Planning Application Reference No.: 3/2025/1005

Address of Development: 7 Church Street

Re: 3/2025/1005 | Former Lloyds Bank 7 Church Street Clitheroe BB7 2DD

Sign 1 - Non Illuminated Conservation Fascia Sign - Scale 1:25

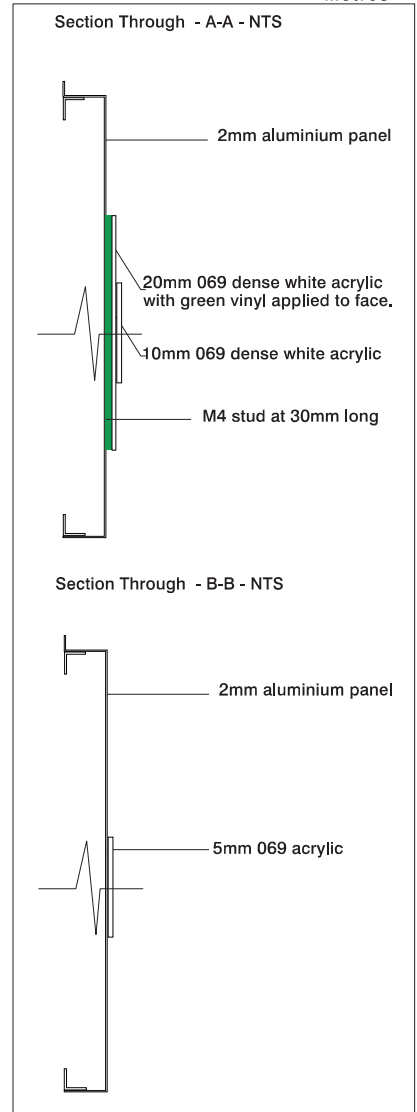
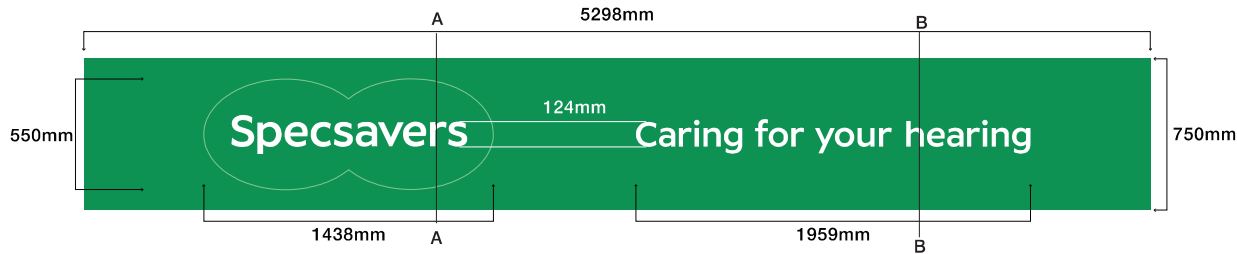
We have concerns over the proposed fascia sign and the vinyl stickers, and their impact on the conservation area. The previous Lloyds Bank signage took the form of individually applied letters, while the new proposed signage would be a large and brightly coloured painted aluminium sign. Individually applied letters are less intrusive while still attracting customers and acting as wayfinding, and previously worked well on this building. As 7 Church Street was originally built as a private residence it does not have a traditional shop front and therefore no logical place for signage, which means a standard fascia sign like the one proposed appears incongruous and distracting. We would urge the applicant to revisit the proposed signage and opt for a more sensitive design that responds to the character of the conservation area and is in keeping with the age and style of the building.

The proposed fascia sign and vinyl stickers in their current form would result in harm to the significance of the NDHA and to the designated Clitheroe Conservation Area. This is contrary to NPPF paragraphs 212, 216 and 219; and to Policy DME4 and Key Statement EN5 of the Ribble Valley Core Strategy, all of which emphasise the importance of conserving the significance of heritage assets and that development in the Clitheroe Conservation Areas should look for opportunities to enhance or better reveal its significance.

Sign 4 - Externally Applied Blank Vinyl - Scale 1:20

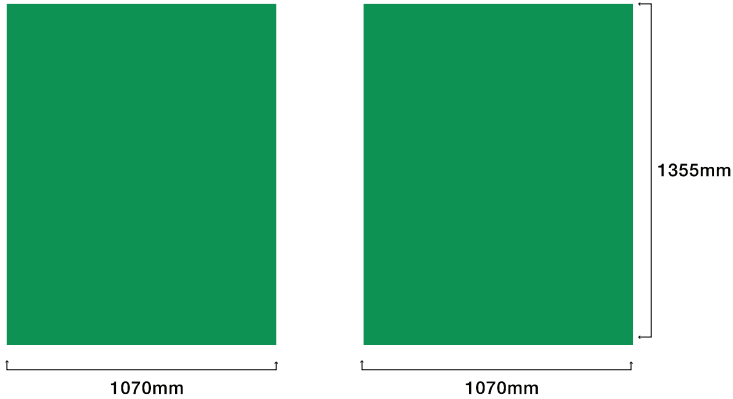
The proposed brightly coloured vinyl stickers on the windows are inappropriate for this location and conflict with the primary goal of preserving the historic character and architectural integrity of the conservation area. As with the signage, we encourage the applicant to seek amended designs that provide an alternative way of obscuring the glass while responding sensitively to the building and its location.
